# CITY OF ALBUQUERQUE

**Re: R & L Carriers, 2350 Aztec Rd NE,**  
**(G-16/D084)**  
**Approval of Permanent Certificate of Occupancy,**  
**Engineer's Revised Stamp Dated: 9-19-08**  
**Engineer's Certification Date: 6-05-09**

**Re: R & L Carriers Grading and Drainage Plan**  
**Engineer's Stamp dated 9-19-08 (G16/D084)**

**Re: R & L Carriers Grading and Drainage Plan  
Engineer's Stamp dated 1-8-08 (G16/D084)**

GRADING & DRAINAGE PLAN

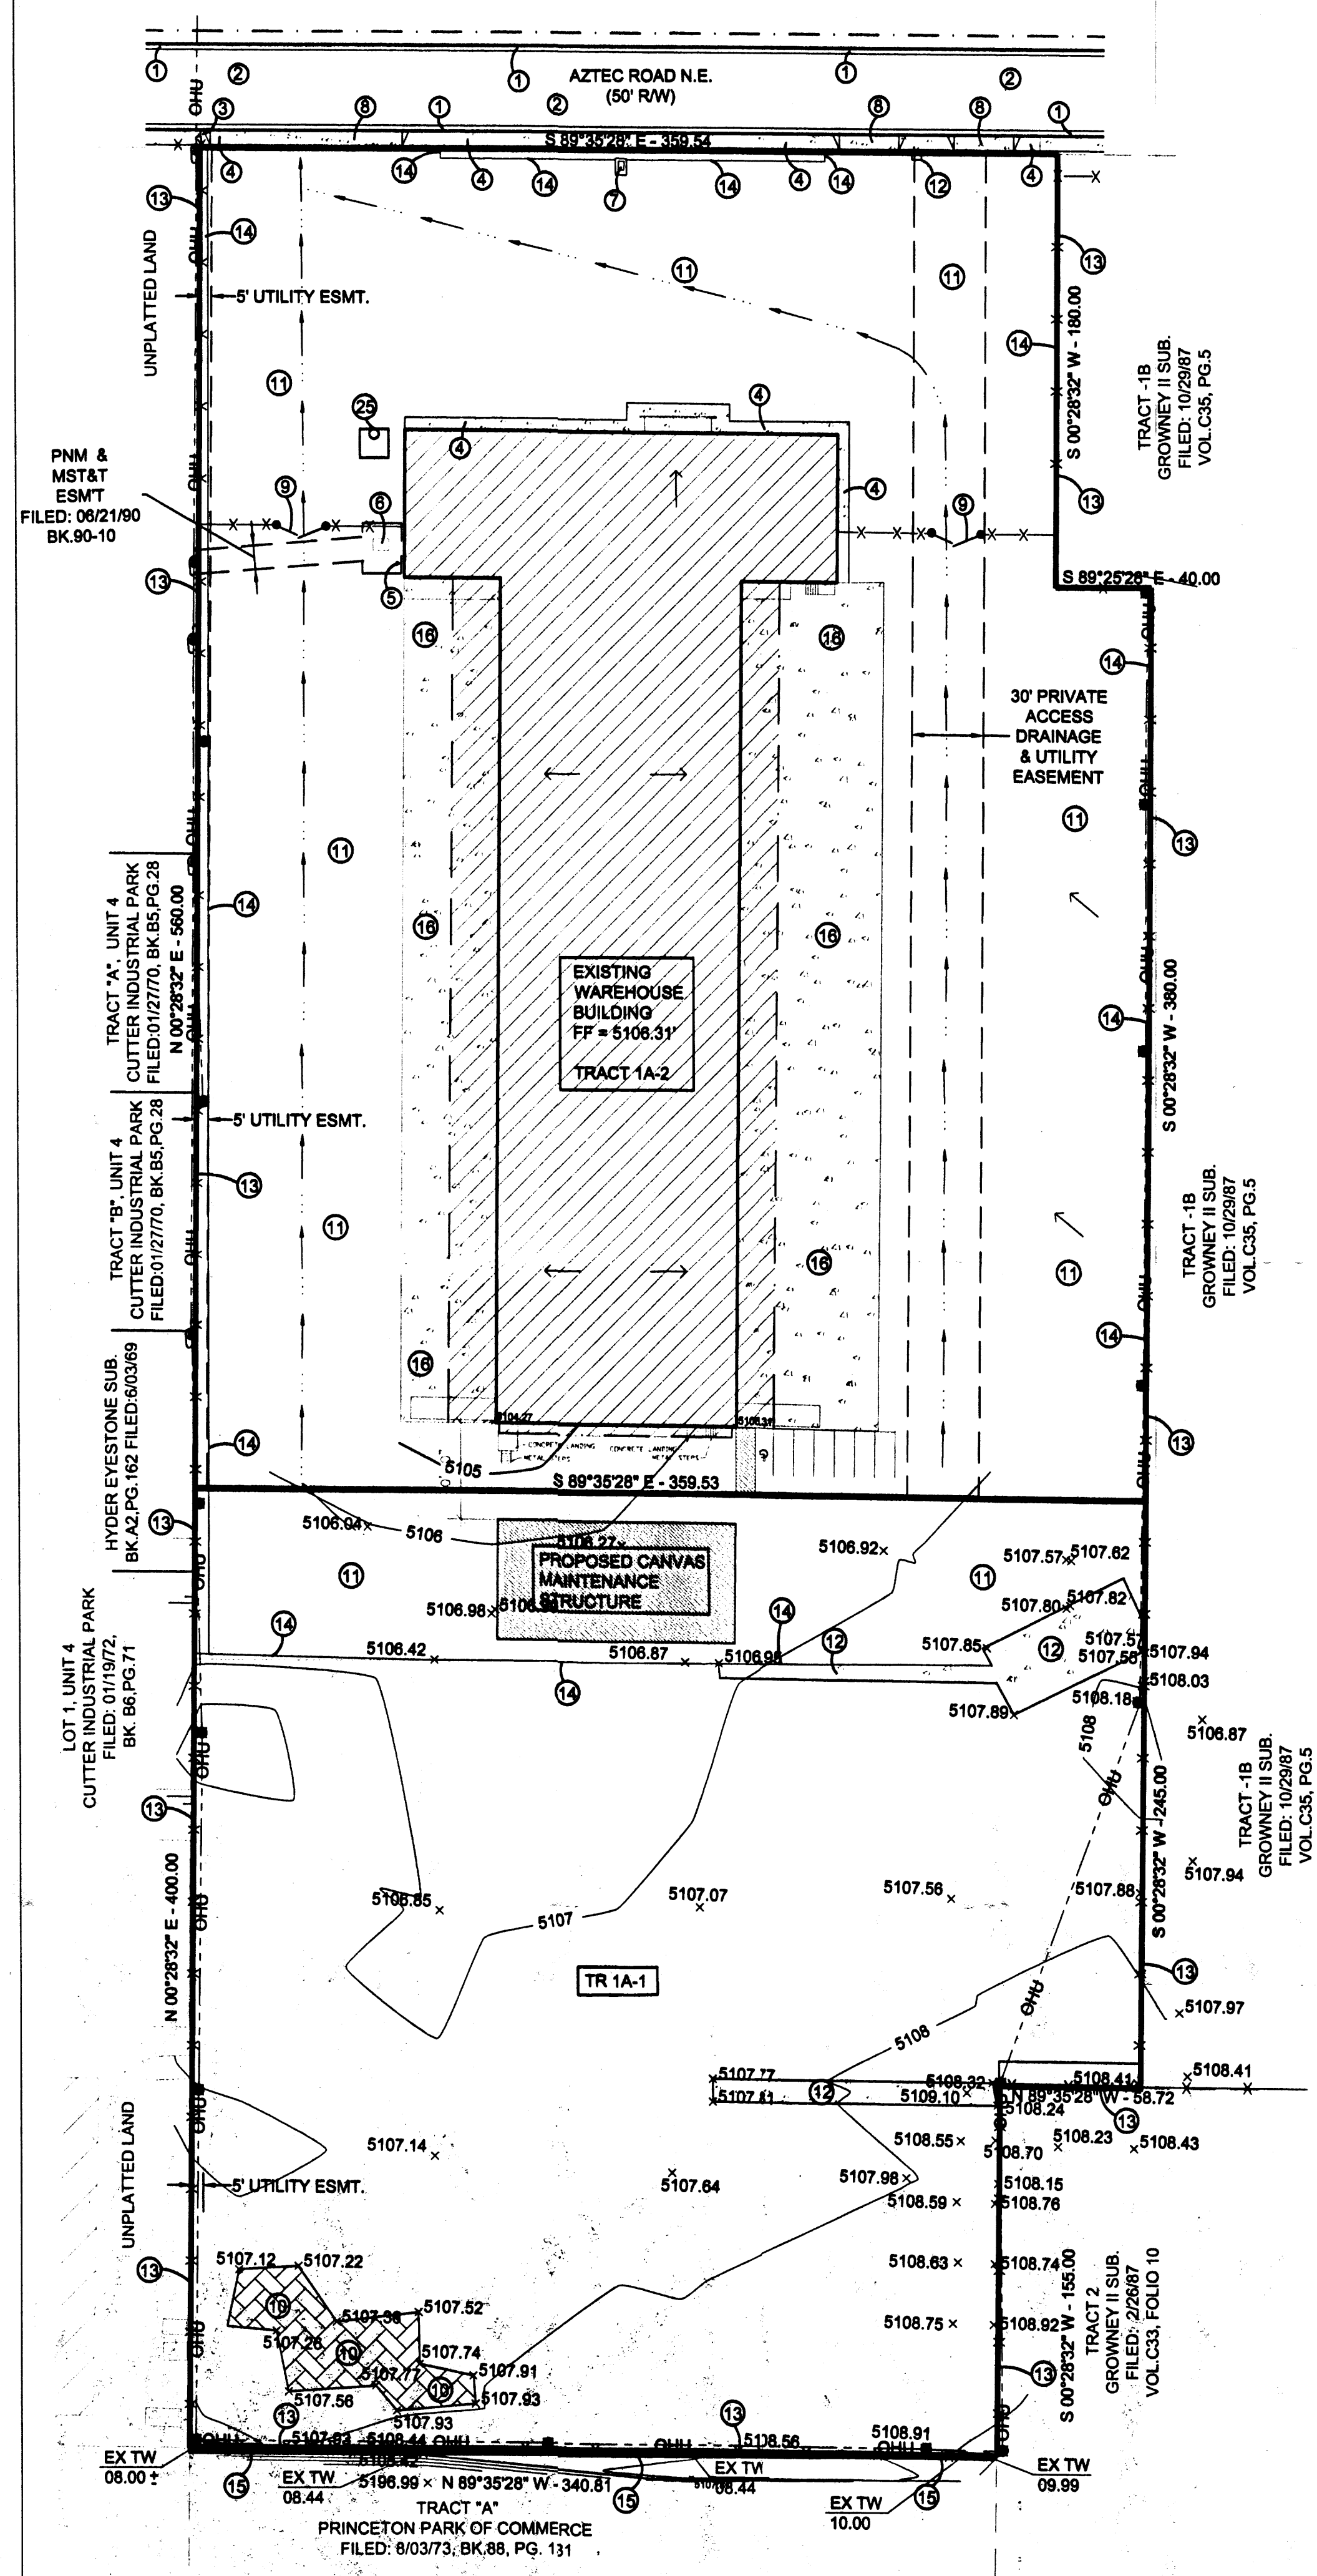
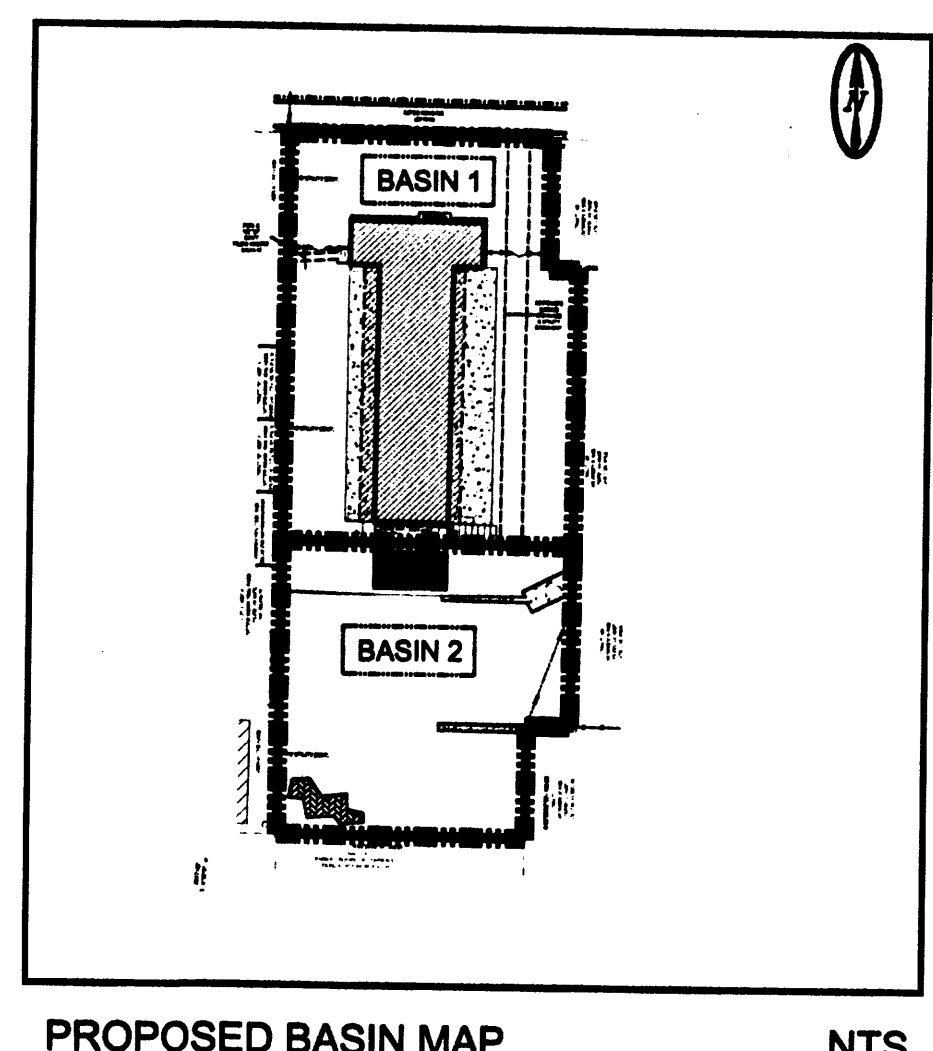
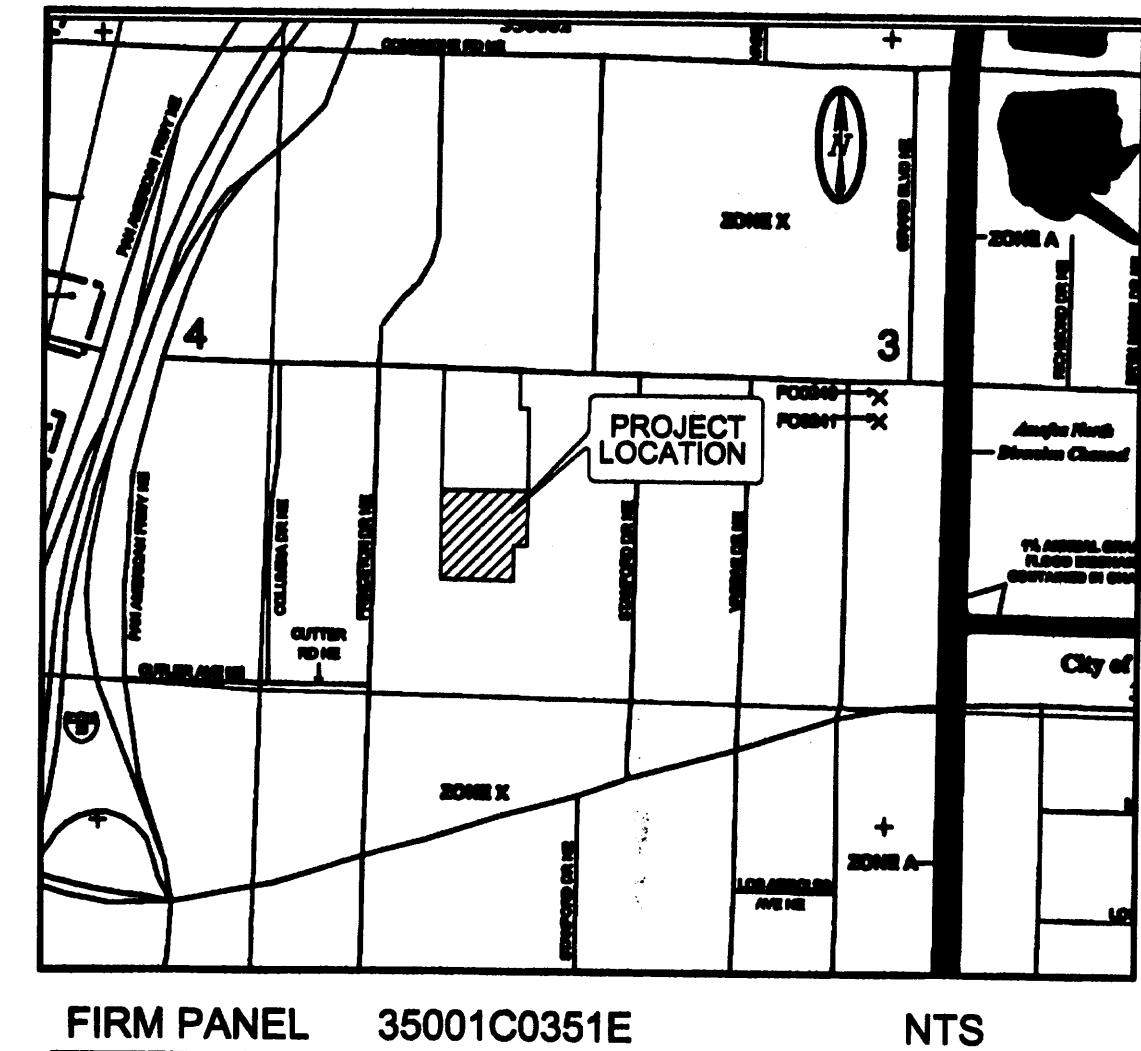
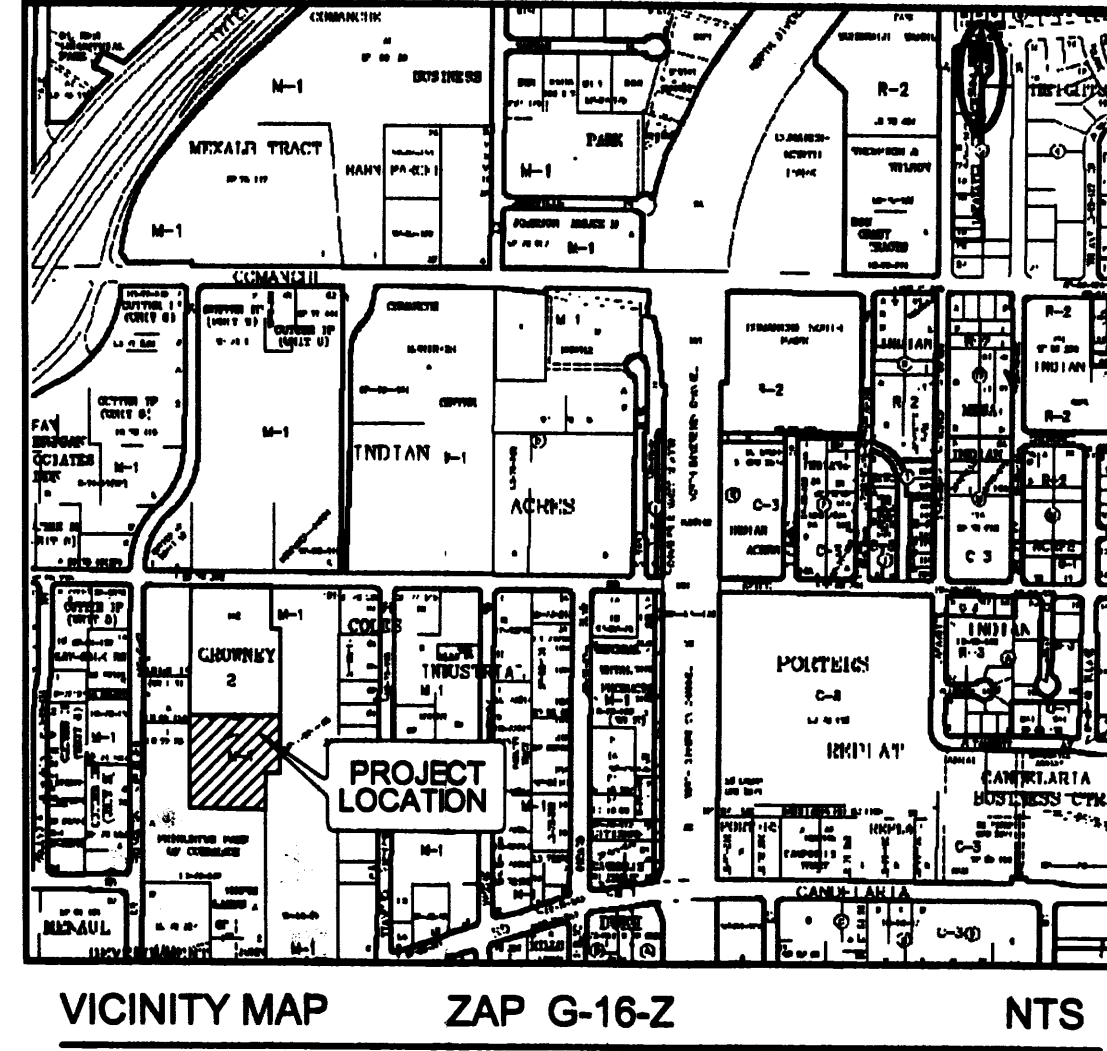
Based upon the information provided in your submittal dated 1-8-08, the above referenced plan cannot be approved for Building Permit until the following comment is addressed:

- Provide build note 24.
